Fire Marshal Division

**Re: Hardee's
2471 NC 87 S.
Cameron, NC 28326**

Application Number BCOM2002-0005

SECTION VIEW - MODEL 3044BD-2  
HOOD - #3

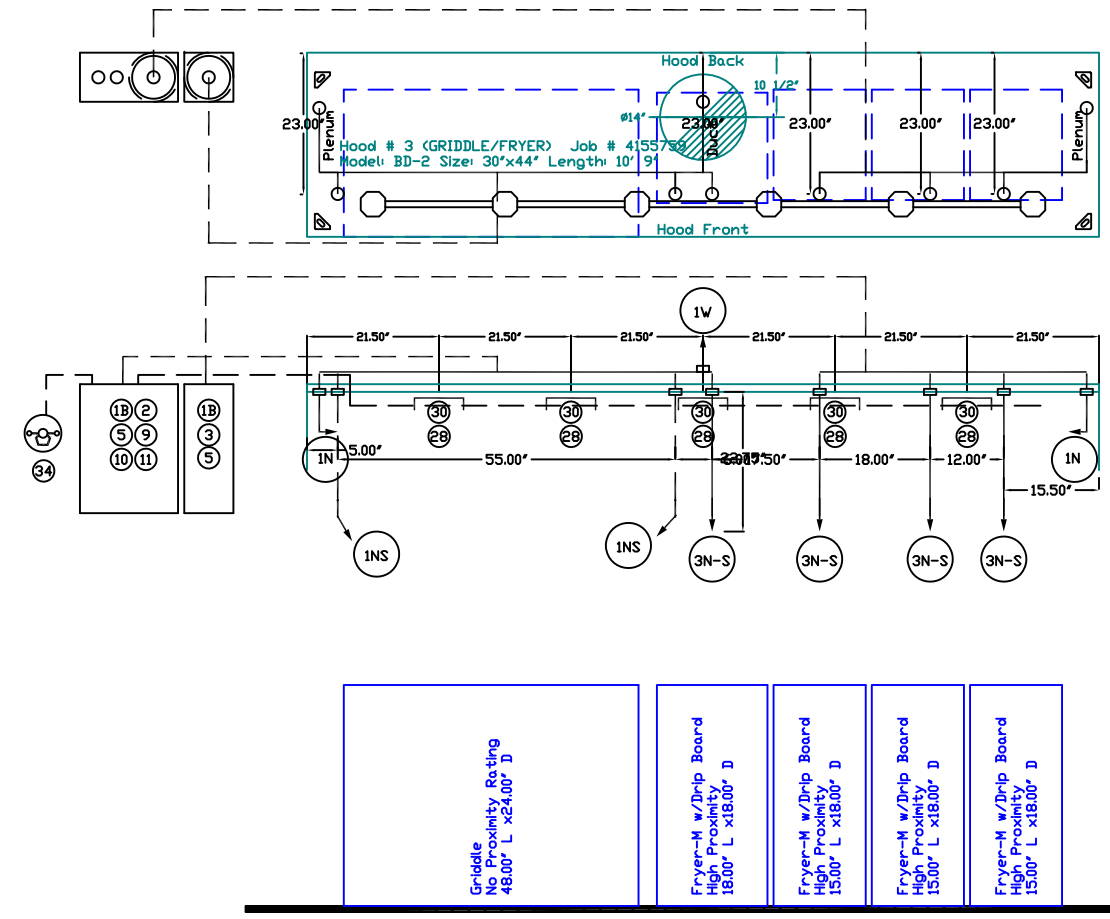
- **Commercial cooking equipment**
 - Portable fire extinguishers shall be provided within a 30-foot (9144 mm) travel distance of commercial-type cooking equipment. Cooking equipment involving vegetable or animal oils and fats shall be protected by a Class K rated portable extinguisher.
- **Acceptance Test**
 - An acceptance test will be conducted by the Fire Marshal's office once system has been installed and pre-tested.
 - Installation shall be per architectural and system submittals and compliant with NFPA-17A.
- **Manual system operation**
 - A manual actuation device shall be located at or near a means of egress from the cooking area, a minimum of 10 feet (3048 mm) and a maximum

of 20 feet (6096 mm) from the kitchen exhaust system.

- The manual actuation device shall be located a minimum of 4.5 feet (1372 mm) and a maximum of 5 feet (1524 mm) above the floor. The manual actuation shall require a maximum force of 40 pounds (178 N) and a maximum movement of 14 inches (356 mm) to actuate the fire suppression system.

- The actuation of the fire suppression system shall automatically shut down the fuel or electrical power supply to equipment under the hood system. The fuel and electrical supply reset shall be manual.

- **System Interconnection**
 - The actuation of the fire suppression system shall automatically shut down the fuel or electrical power supply to any equipment under the hood system. The fuel and electrical supply reset shall be manual.
